From: Sasha Osbourne
Sent: 22 September
To: Sian Eggington
Subject: Re: Y/90/20/HH

Elevations: Please provide scaled elevations of the proposed trellis stating the max height of the trellis. Please submit this at a scale of 1:50 or 1:100 with a scale bar.

DRAWING
SITE PLAN
BOUNDARY DETAIL
 DRAWING No
324/01
 SCALE 1:500
 DATE OCT 20
 DRAWN LA
 CHECKED

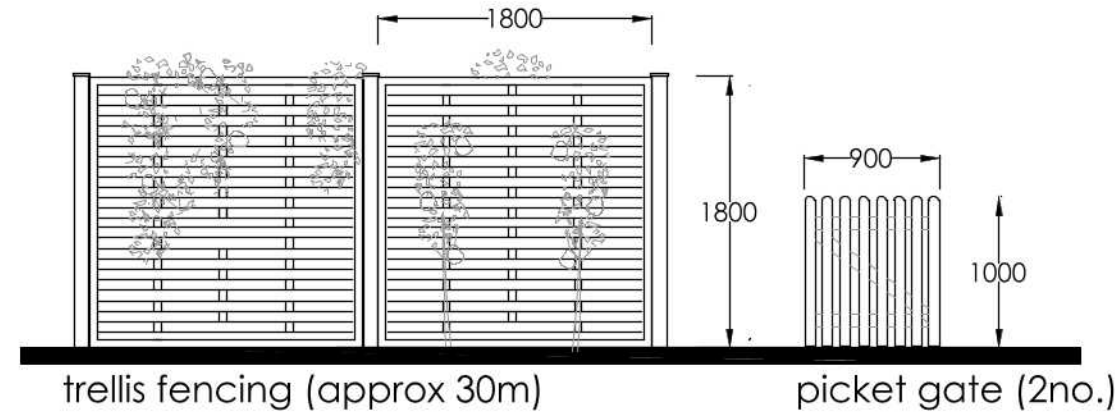
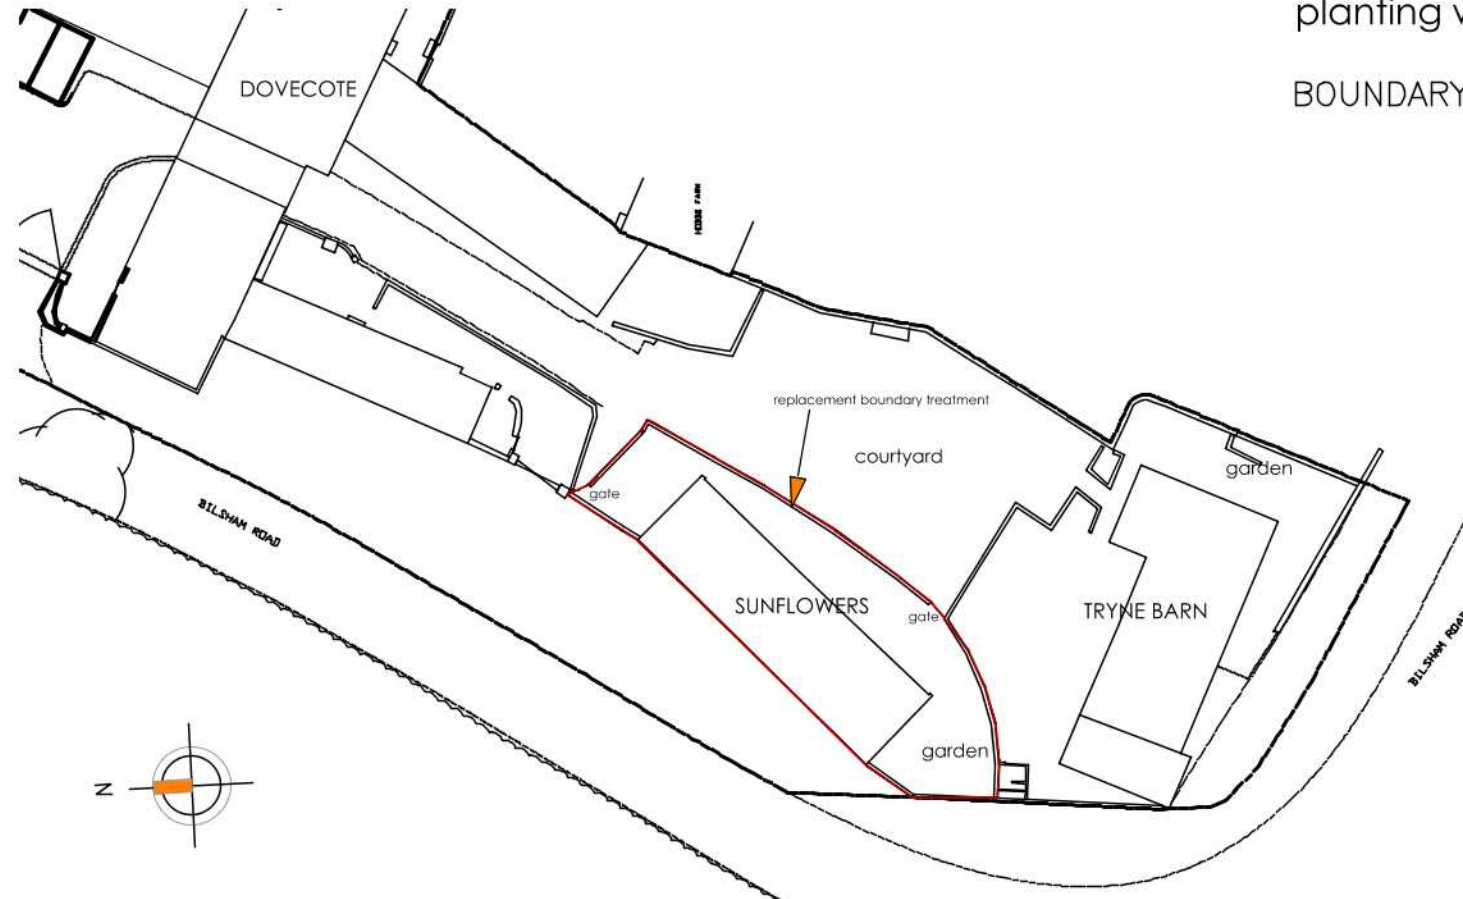
Thank you for your emails, the location plan needs the red outline around the entire site. With your permission I can amend this for you. For the elevation this can be hand drawn, we would need them for the gate and trellis. It does not have to be detailed but would need to measure to scale. As the trellis is going across the property you would only need to submit a section like below it would need to state the maximum height e.g. 2m on the plan and a note should be added to the plan stating it will run for X meters. I would advise that the best scale to use on A4 for this would be either 1:20 which would be 5cm = 1m. or alternatively 1:50 which is 2cm = 1m. The gate would need to state the height and the width. Examples of both can be found on google images.

Block Plan: Please provide a proposed block plan showing the location of the proposed trellis.

LOCATION PLAN AT 1:1250 SCALE

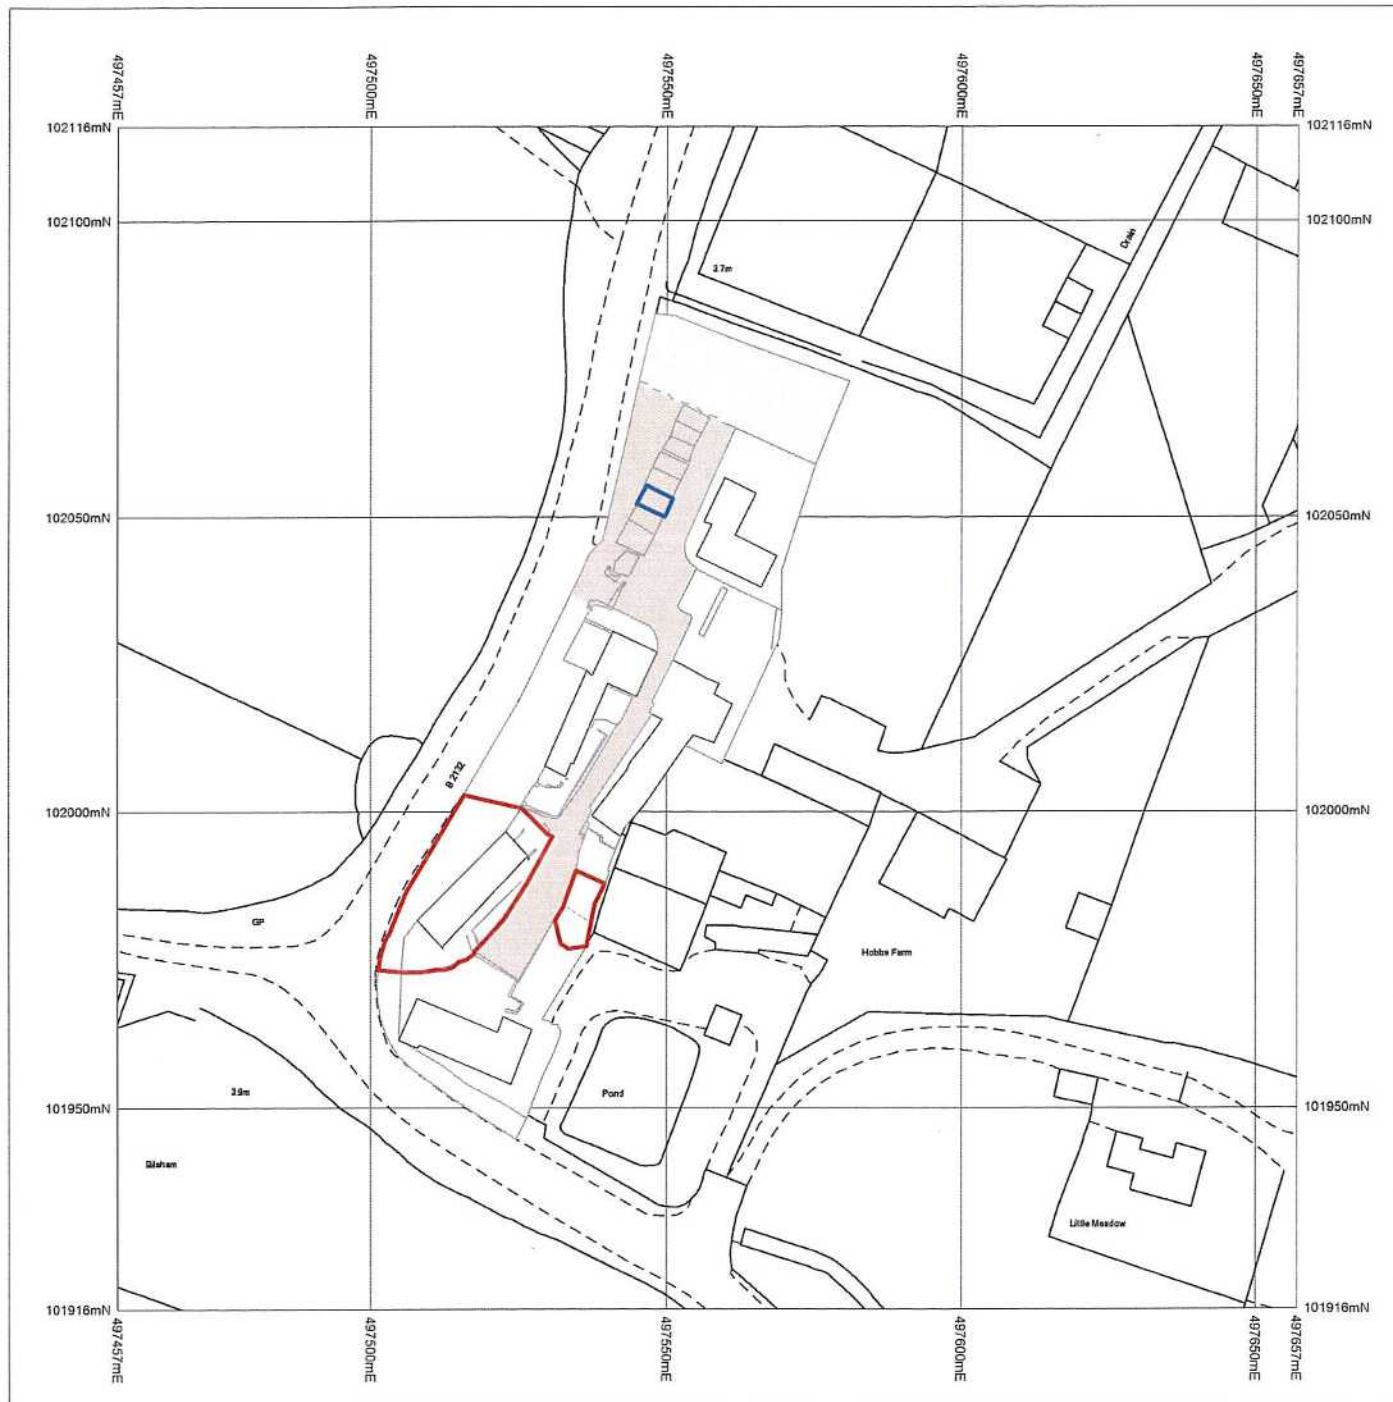
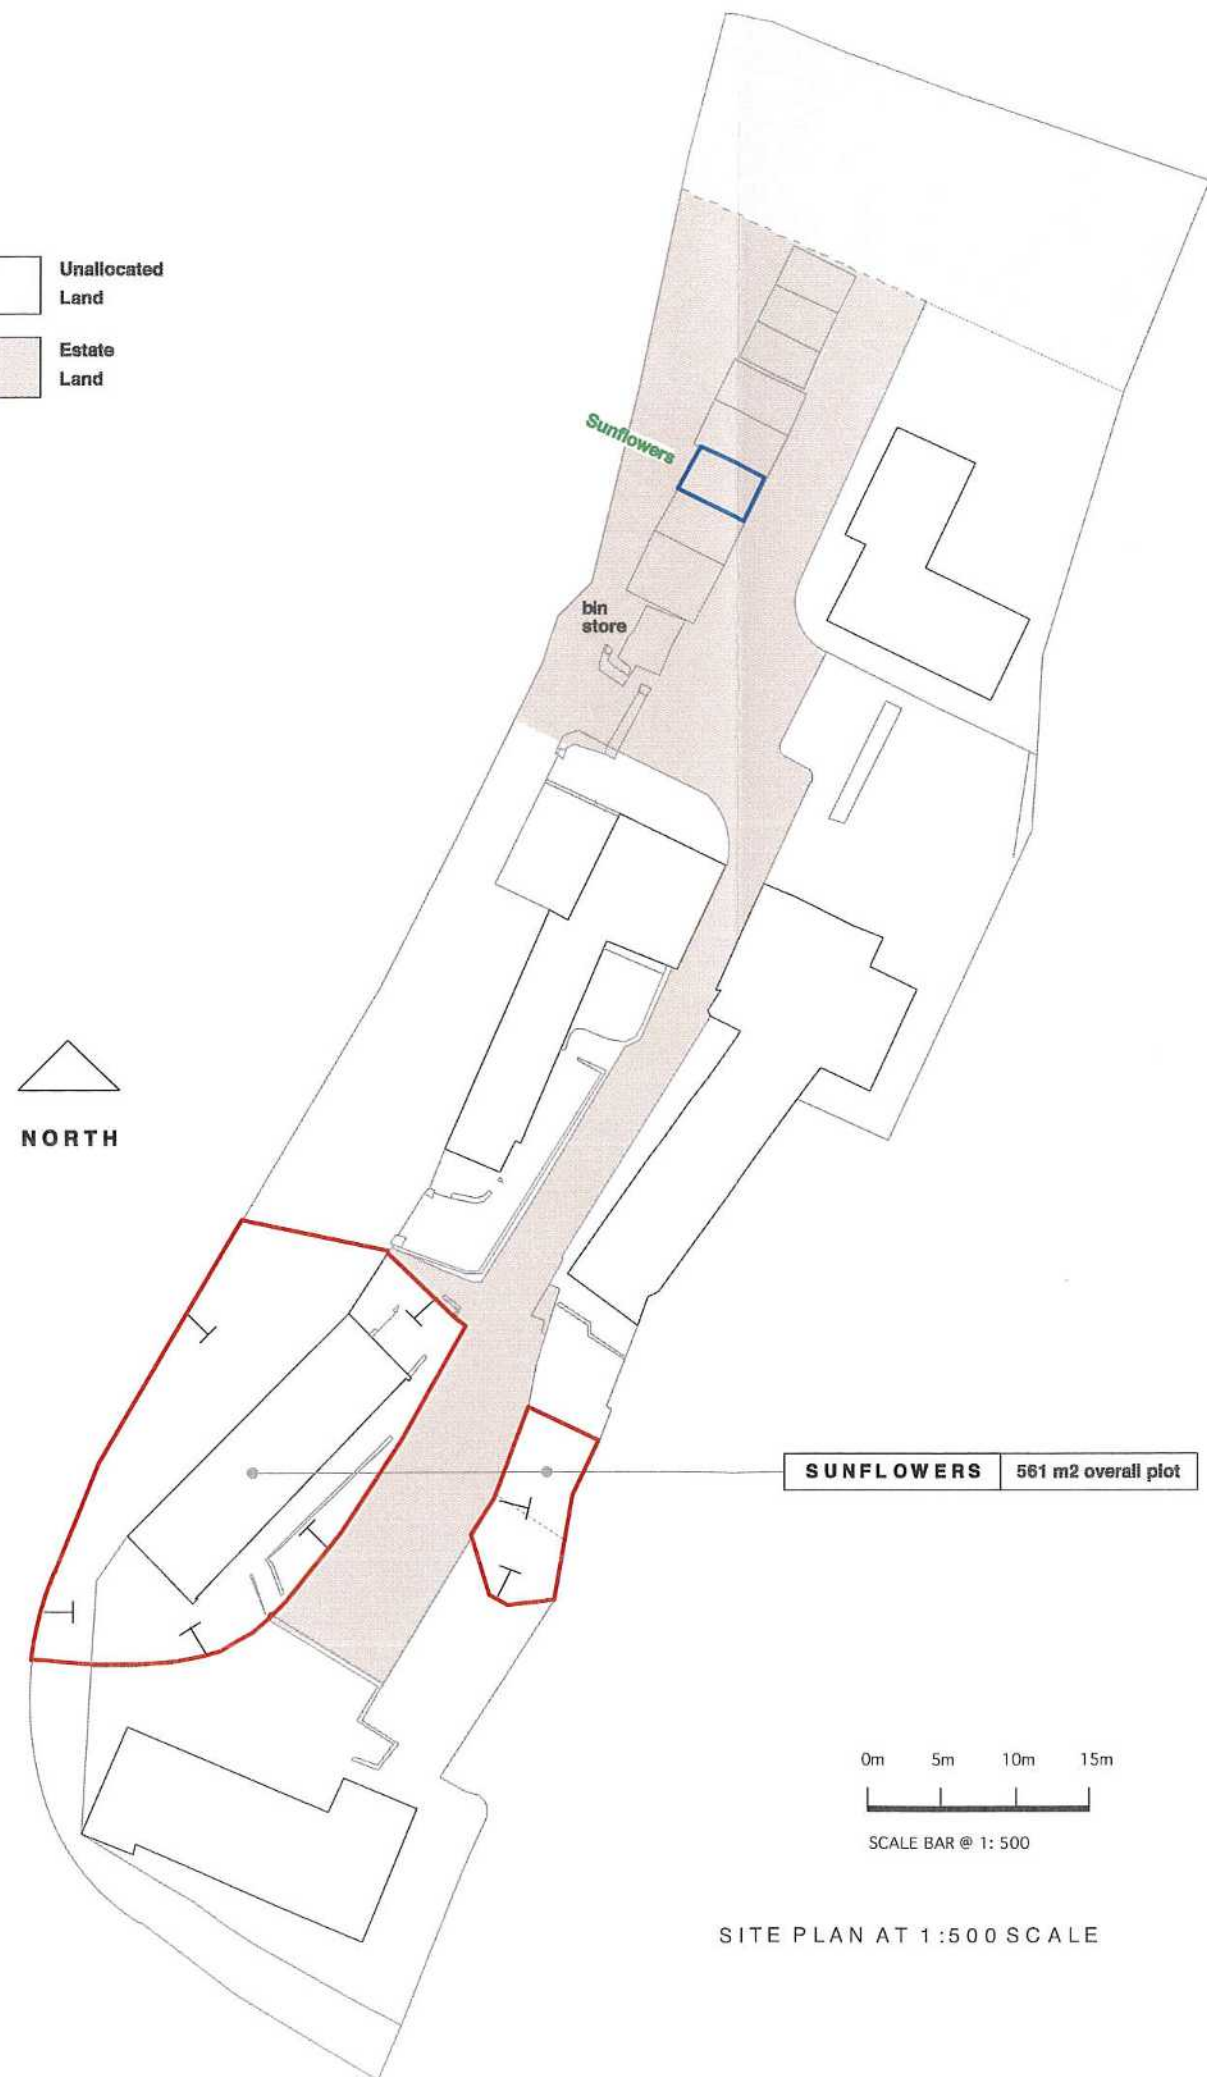
Location Plan: You are required to have a red outline around the proposed site on the block and location plan
